# CITY OF ALBUQUERQUE

**RE: Mesa Del Sol Neighborhood - Montage Units 3 & 4  
Drainage Report for Preliminary Plat Approval and Grading Permit  
Engineer's Stamp Date 4-25-2014 (File: R16D006)**

Based upon the information provided in your submittal received 4-25-14, the above referenced Drainage Report cannot be approved for Preliminary Plat Approval by the DRB or Grading Permit until the following comments are addressed:

POND 4 TO BE UPSIZED AND IMPROVED BY FUTURE PROJECTS AS THOSE PROJECTS DEVELOP.

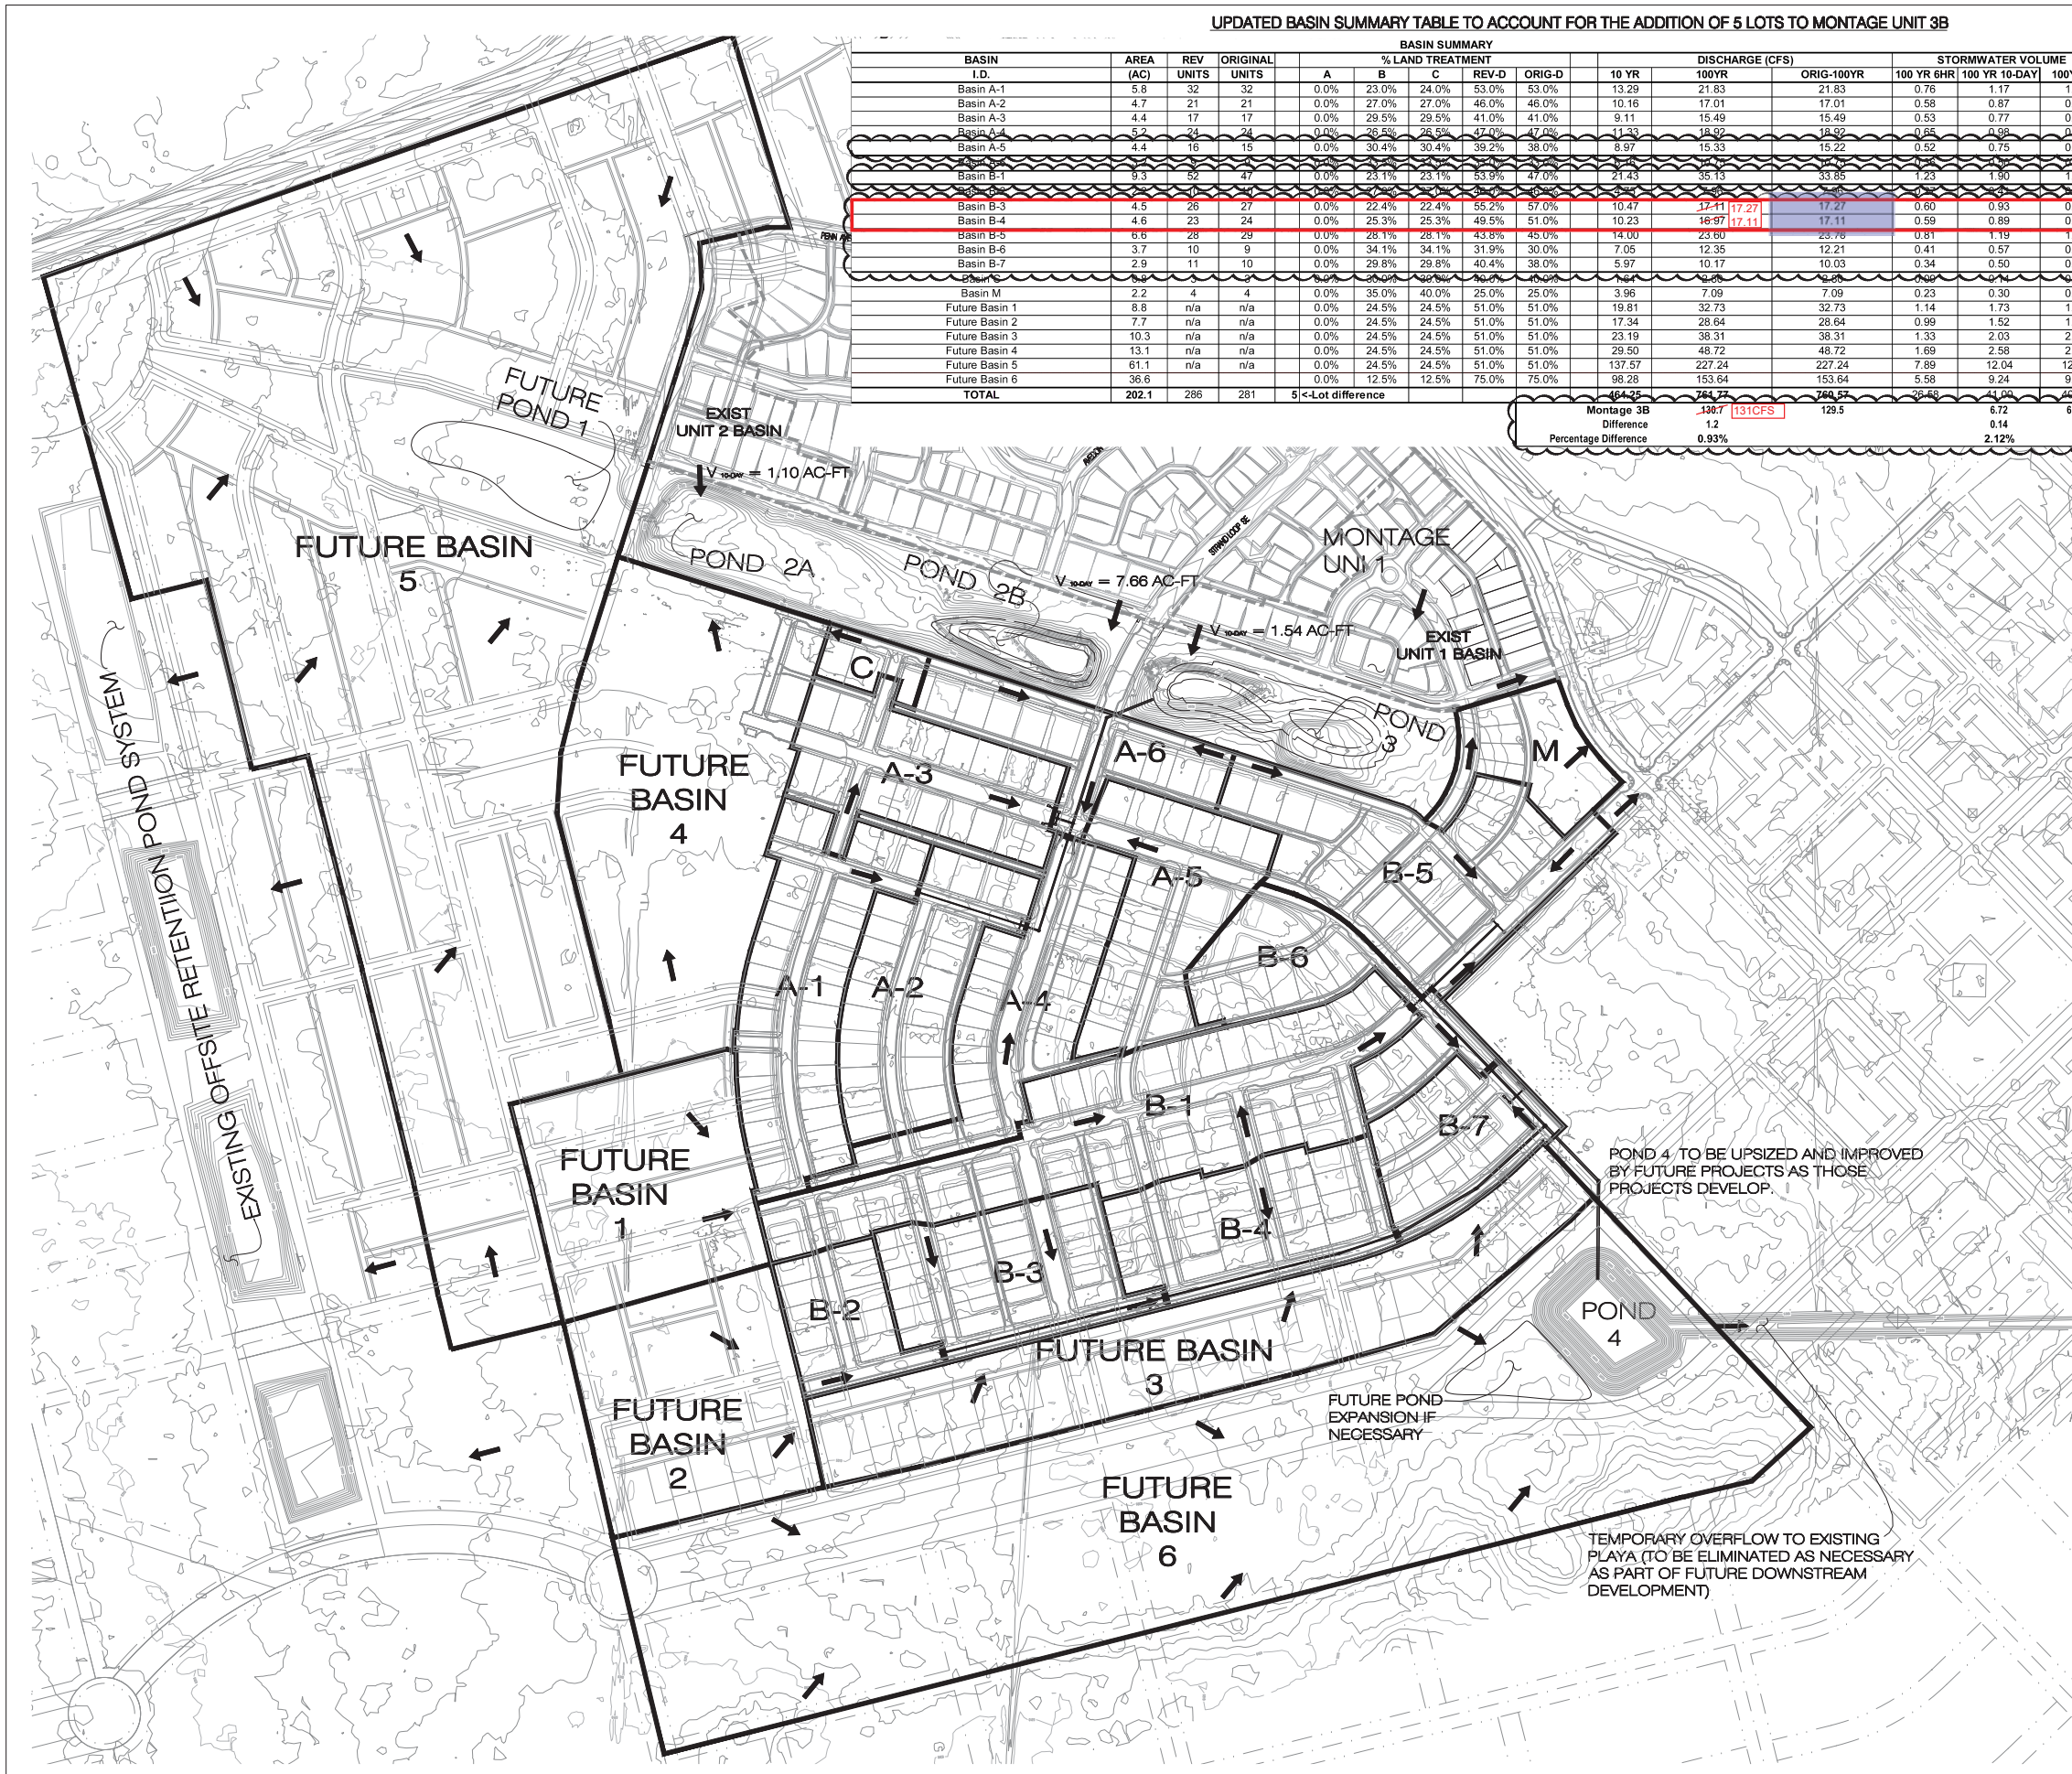
2. While Temporary Pond 4 will be reconfigured in the future, there is no long term or comprehensive plan to determine where runoff from Basins B-1 through B-7 will ultimately be retained. Without a long-term or more comprehensive plan, it is not possible to determine if the proposed storm drain system and proposed grading is acceptable for future development.

3. The predominant drainage strategy in the Level A and Level B Plans is to strategically locate retention ponds *due to the flat slopes*. Given these flat slopes and the long distance to the playa, will flows that are now proposed to be retained/detained by Pond 4 be able to be discharged to the playa in the future?

5. Pond 4 shows a discharge *towards* the Community Center. Level B Plan, page 13, states “storm water runoff would be conveyed out of the Centers toward trunk open space corridors.” A long-term or comprehensive plan would be required to address this apparent conflict.

LEVEL B OVERALL STORMWATER PLAN

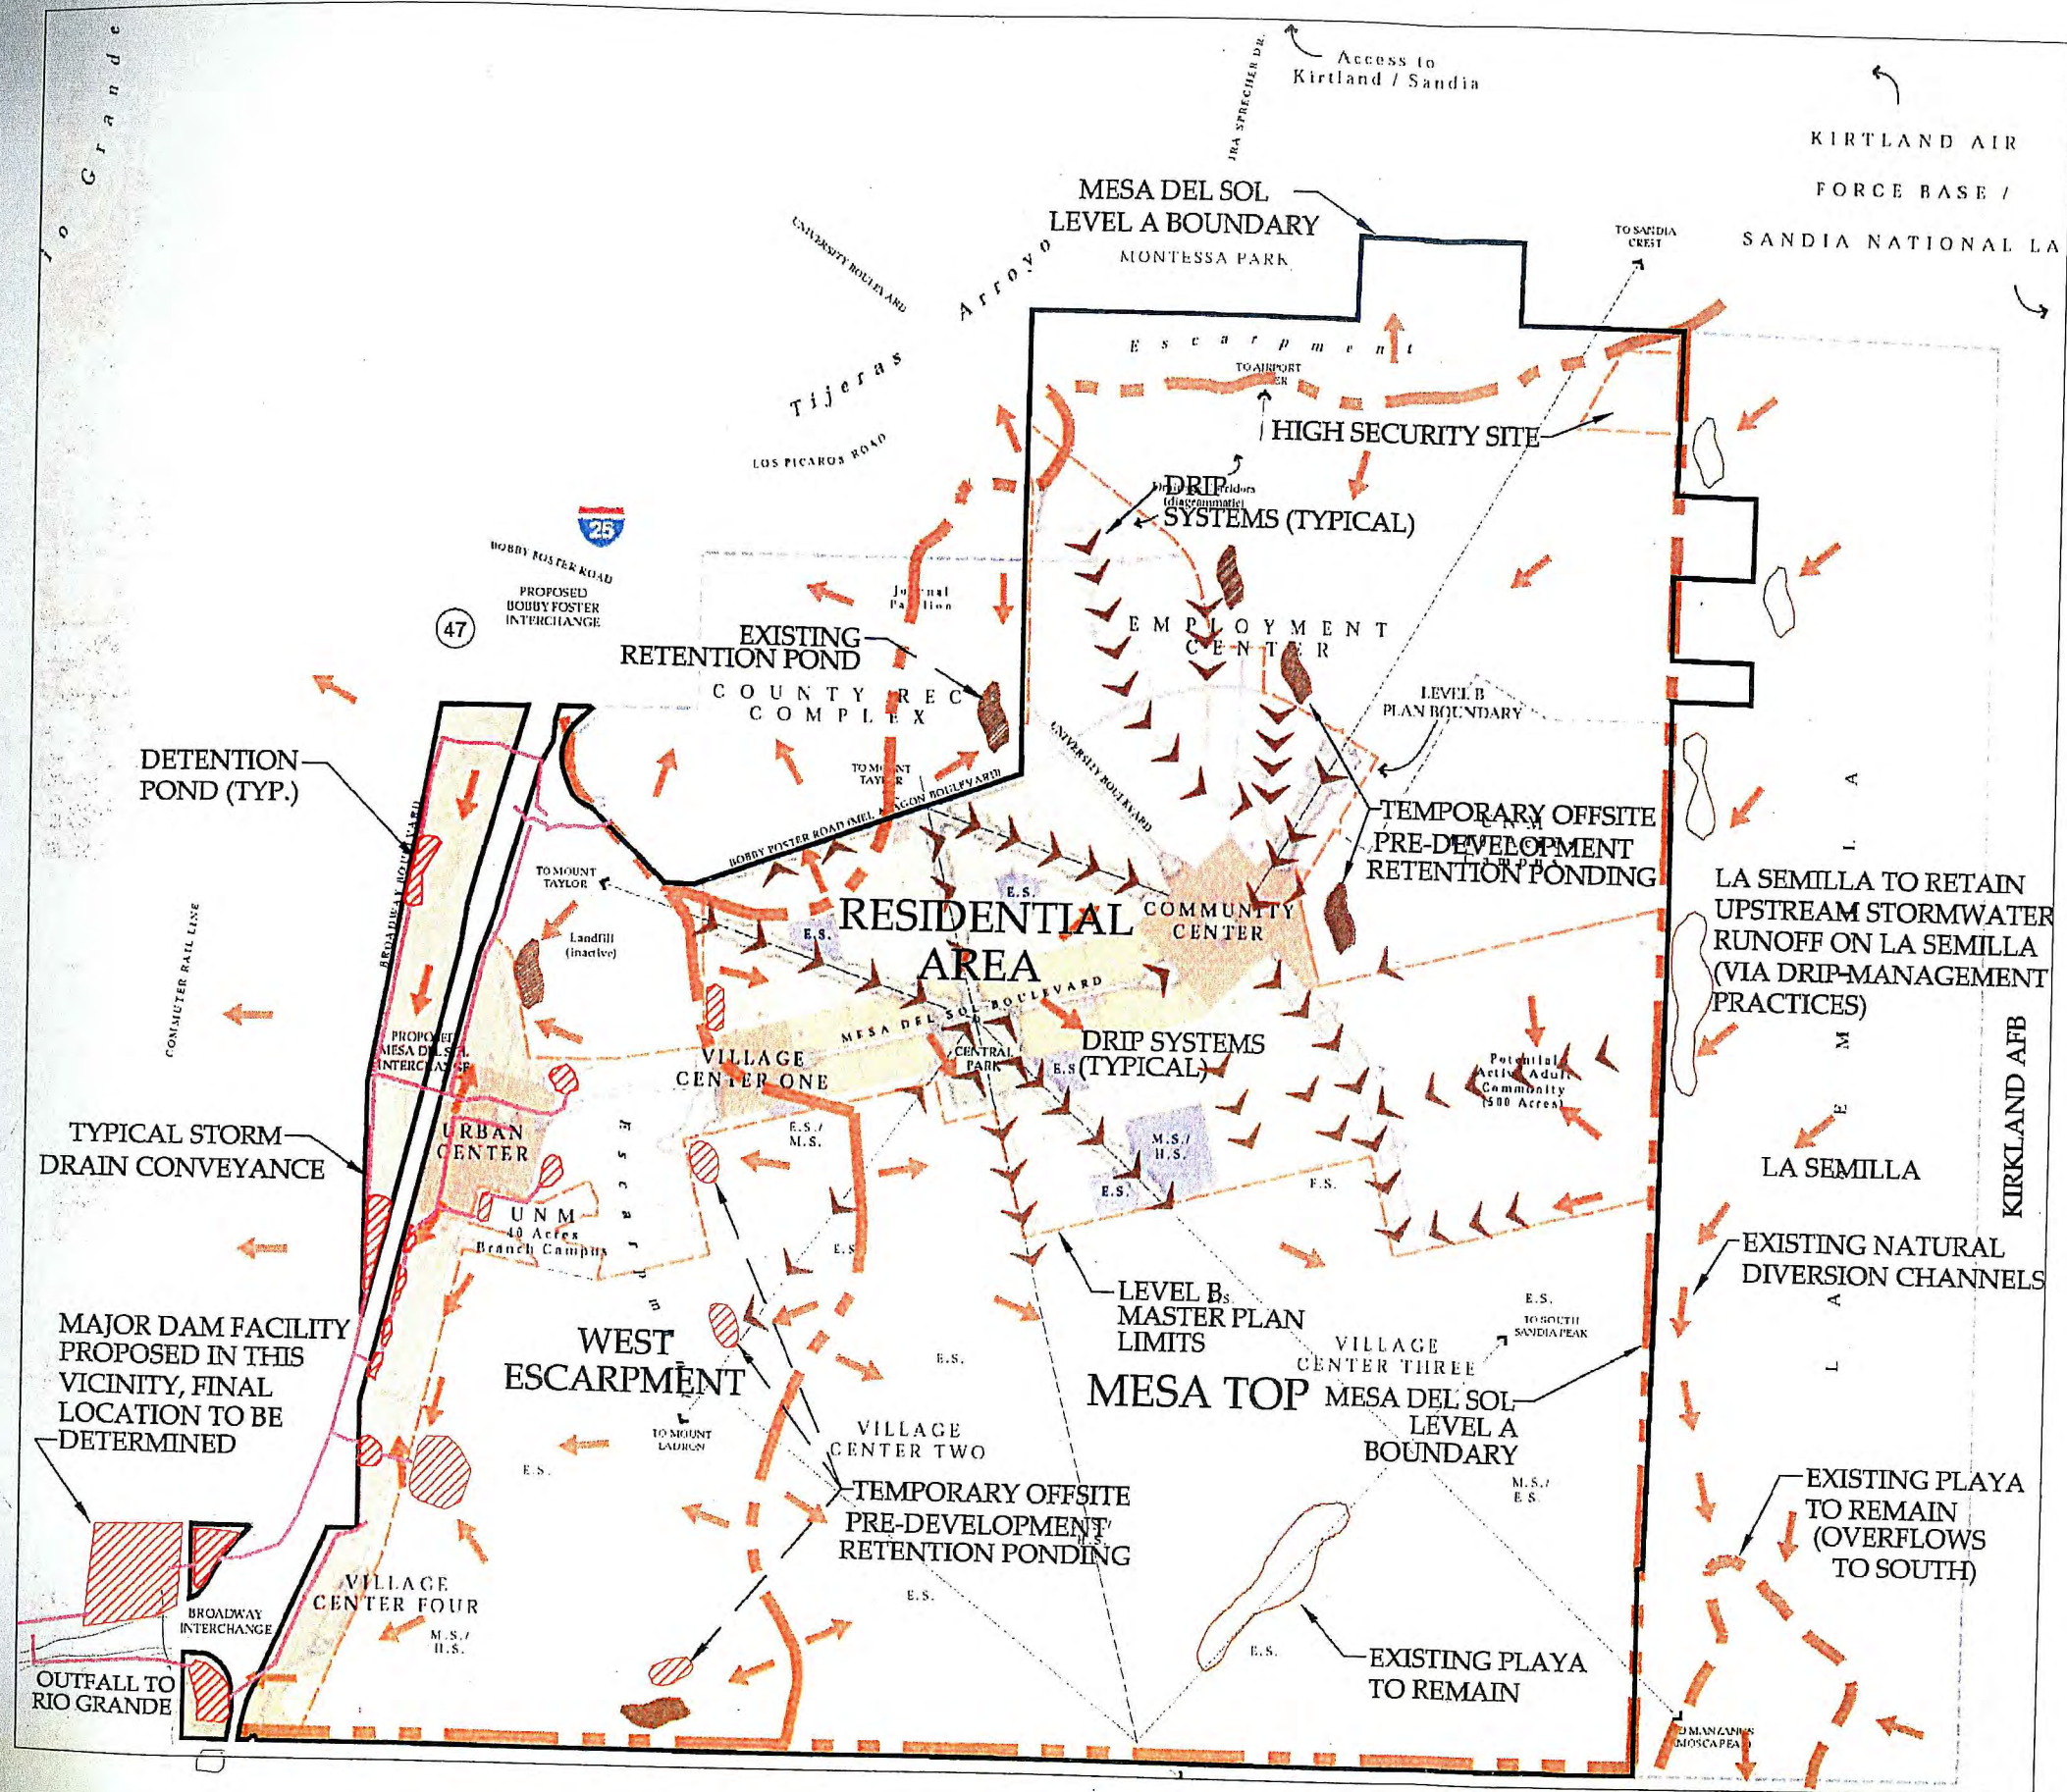
1. The predominant drainage strategy in the Level A and Level B Plans is to use a “system of retention ponds, self-contained and not necessarily connected to any other major drainage areas”, or DRIPs. While Proposed Basins A-1 through A-5 drain to DRIPs, Basins B-1 through B-7 do not. Instead they drain to Temporary Pond 4.

6. The Proposed Basins do not include areas generally to the south and west of the proposed development. While the basin boundaries delineated in the Level B Plan were for illustrative purposes, they were intended to closely resemble the existing drainage situation present in the area (see Level B Plan, page 107). Therefore, basin boundaries should more closely approximate those shown on the Level B plan unless it is shown that those boundaries are in error.
